Planning & Urban Development Department

RE: Review Comments for Single Family Site Plan

Project Name: Juve Single Family
Project ID: 2014-02531
Project Address: 67 Merrill Street **CBL:** 014-L-020001

SITE PLAN-SURVEY  
AT  
67 MERRILL STREET, PORTLAND, MAINE  
MADE FOR  
MERRILL STREET RESTORATIONS, LLC  
40 PORTLAND PIER #11, PORTLAND, MAINE

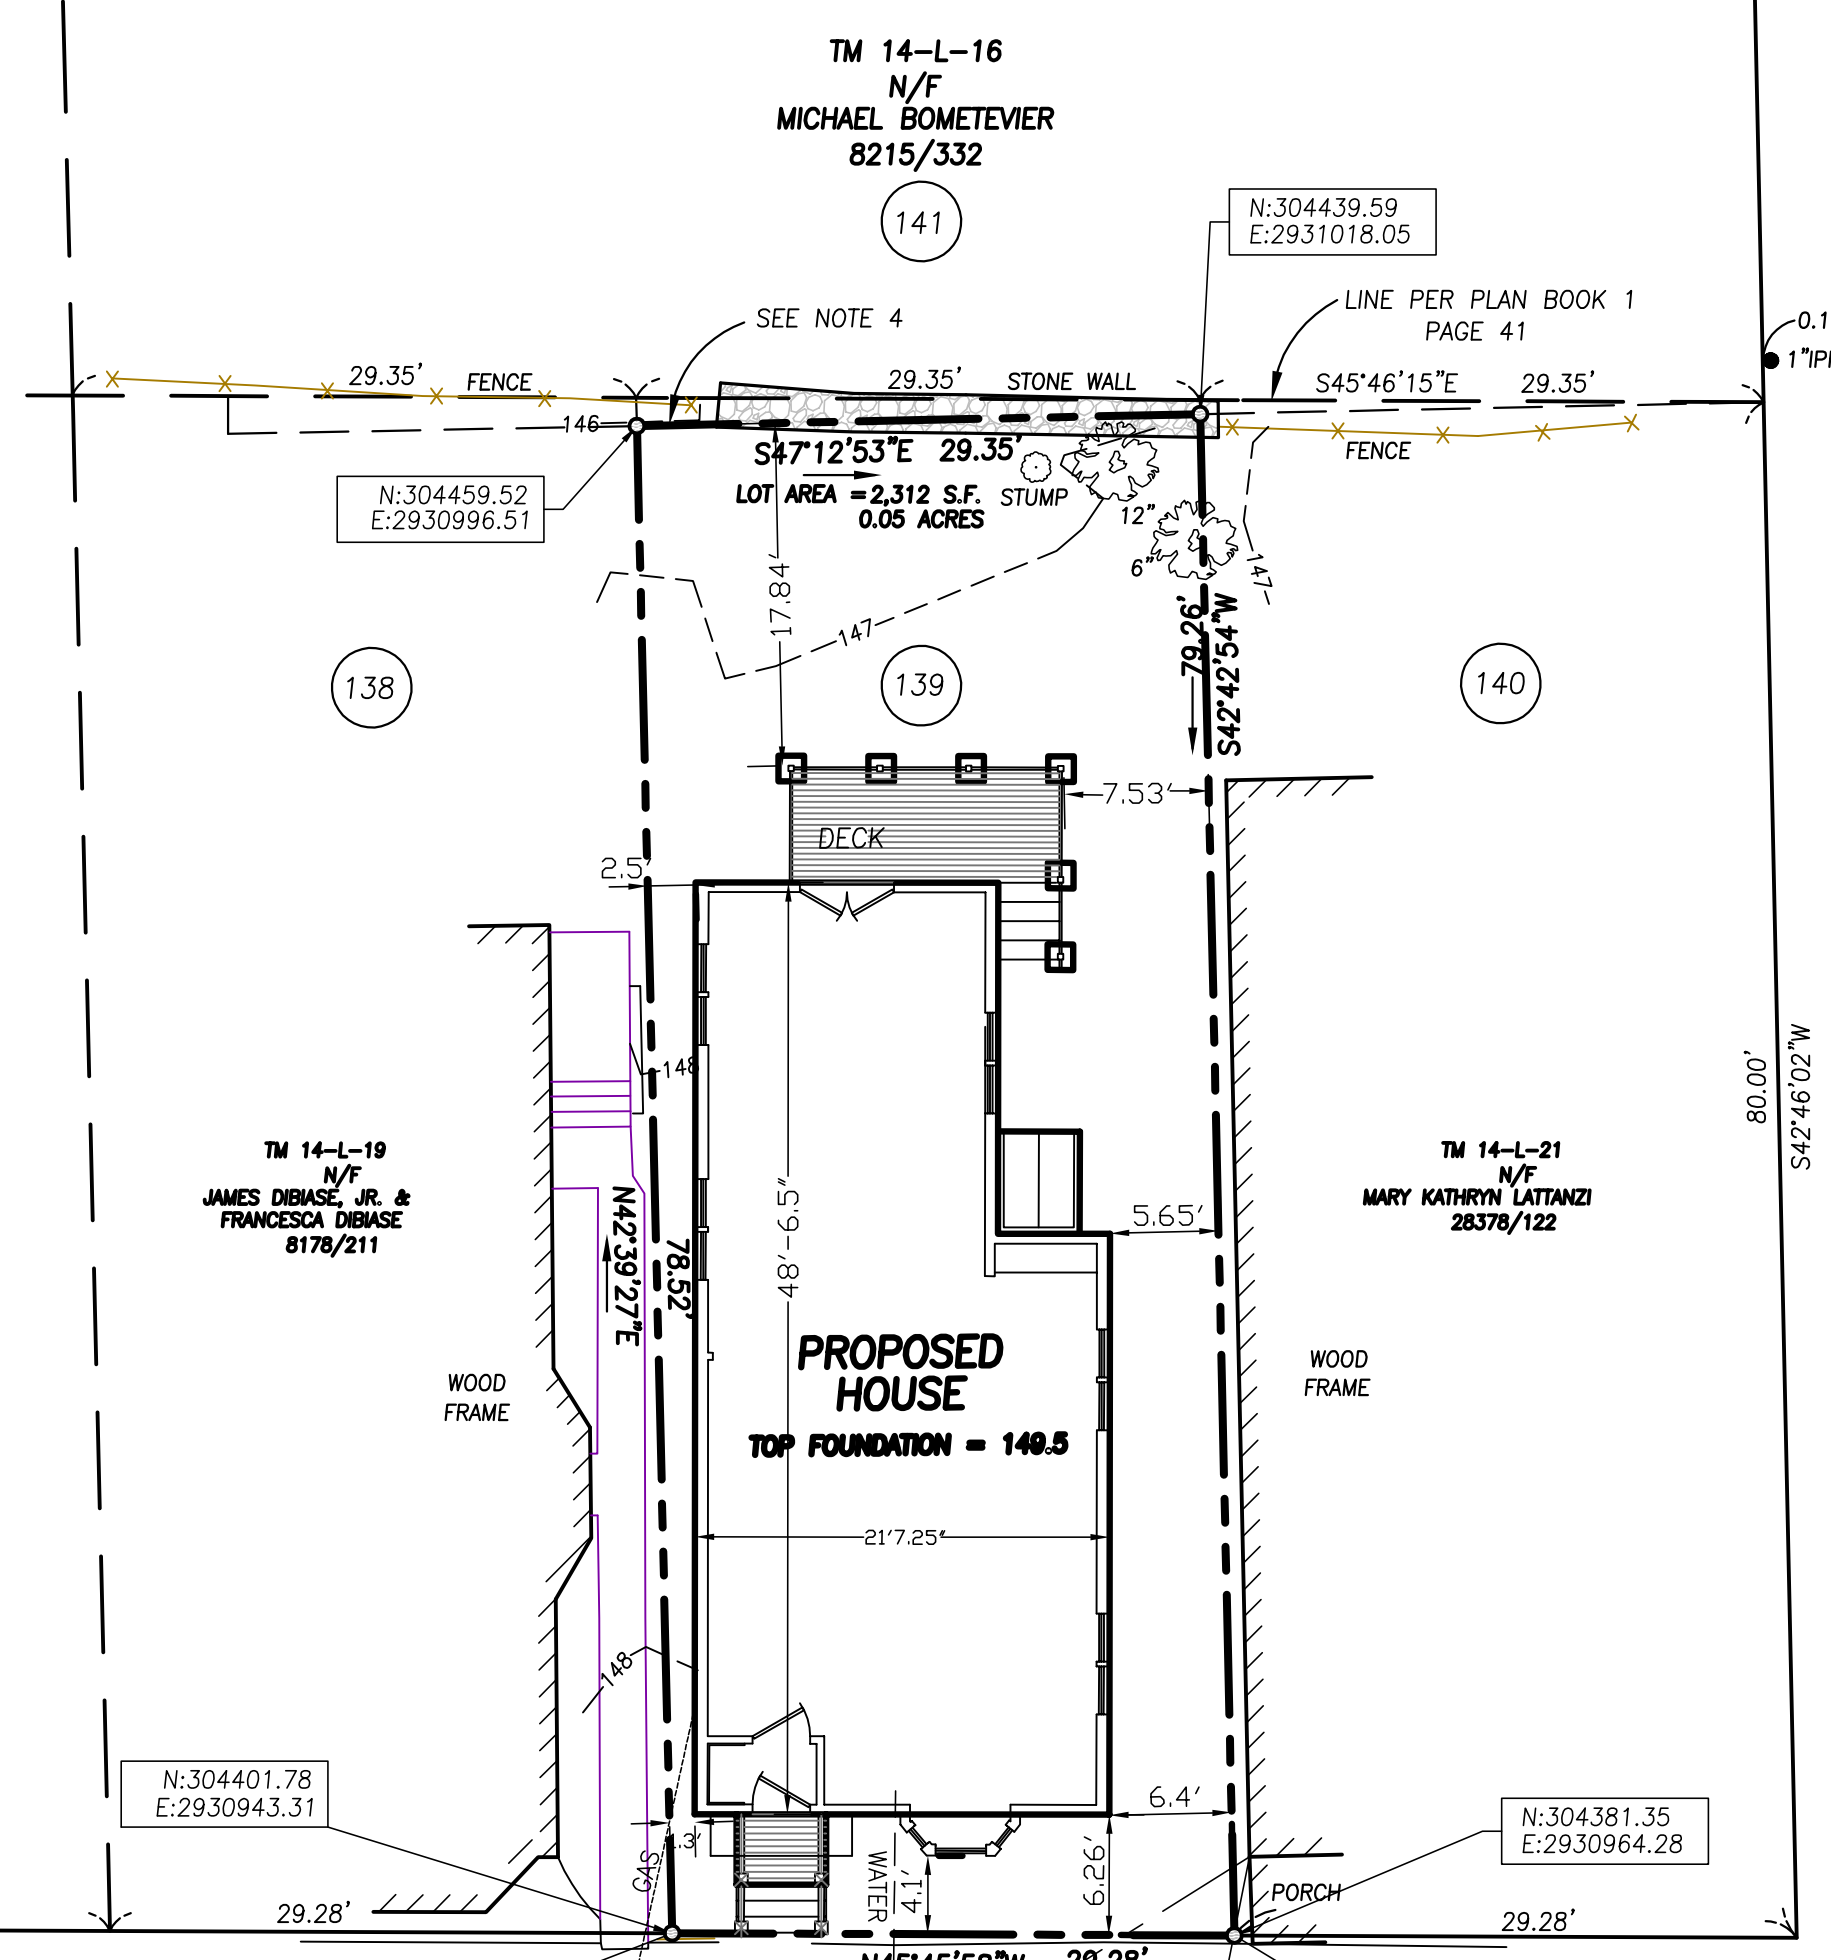
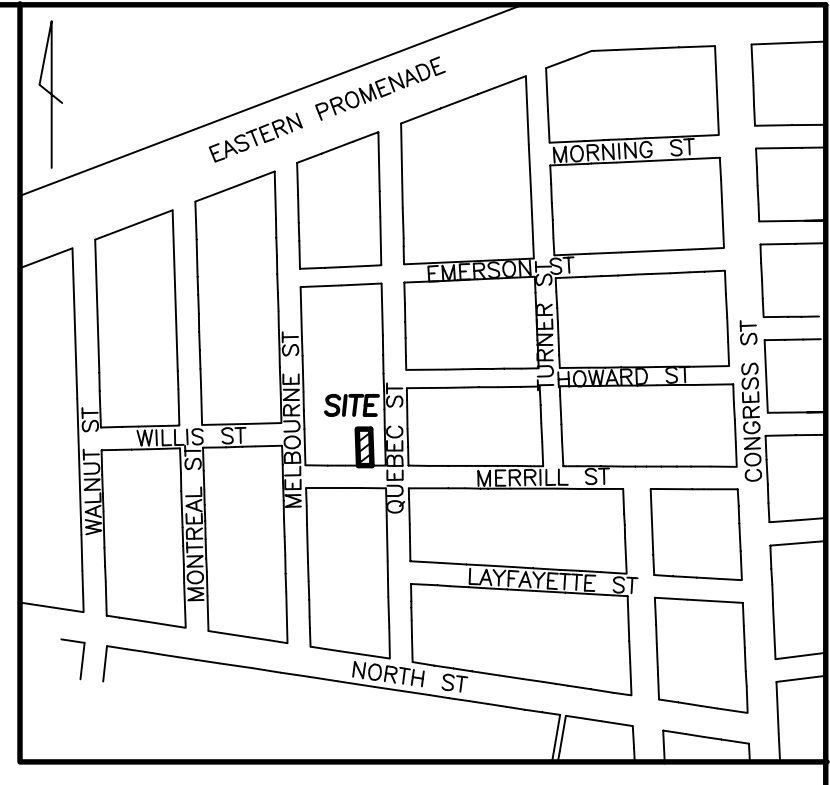
1. Please submit a clear and legible survey that meets the following survey standards for a Level I Minor Residential site plan application:
 - A revision block with a number and date indicating the revision status. The revision block shall be located in the title block or adjacent to it.
 - Street Status: The Status of the street shall be shown; IE Accepted City Street, Continued Paper Street, Discontinued City Street, Vacated Paper Street, or new Proposed Street as per the project submission.

1. Please submit a revised site plan that includes the following information:
 - A note must be added to the site plan confirming that the existing paved area will be removed. City staff is also requiring the curb cut in front of the house be closed. The site plan must be revised to reflect this requirement.

- Add the location of the proposed sewer lateral from the street to the dwelling, to the site plan. Note, you will need to confirm with each utility provider that the existing utility lines can be re-used and that they meet current codes and standards.

- Add the soil type to the site plan.
 - Add to the site plan, the required erosion control measures ie. silt fence or erosion control mix (erosion control plan) in the appropriate areas.

- Add to the site plan, the required 2 street trees along the street frontage, meeting the City's minimum arboricultural standards. If street trees cannot be added to your frontage, a contribution to the City's tree fund is required. A note must be added to the site plan reflecting this requirement.

- Add to the site plan, the location, area, and limits of the proposed site disturbance.
 - Show on the site plan where the foundation drain will outlet.
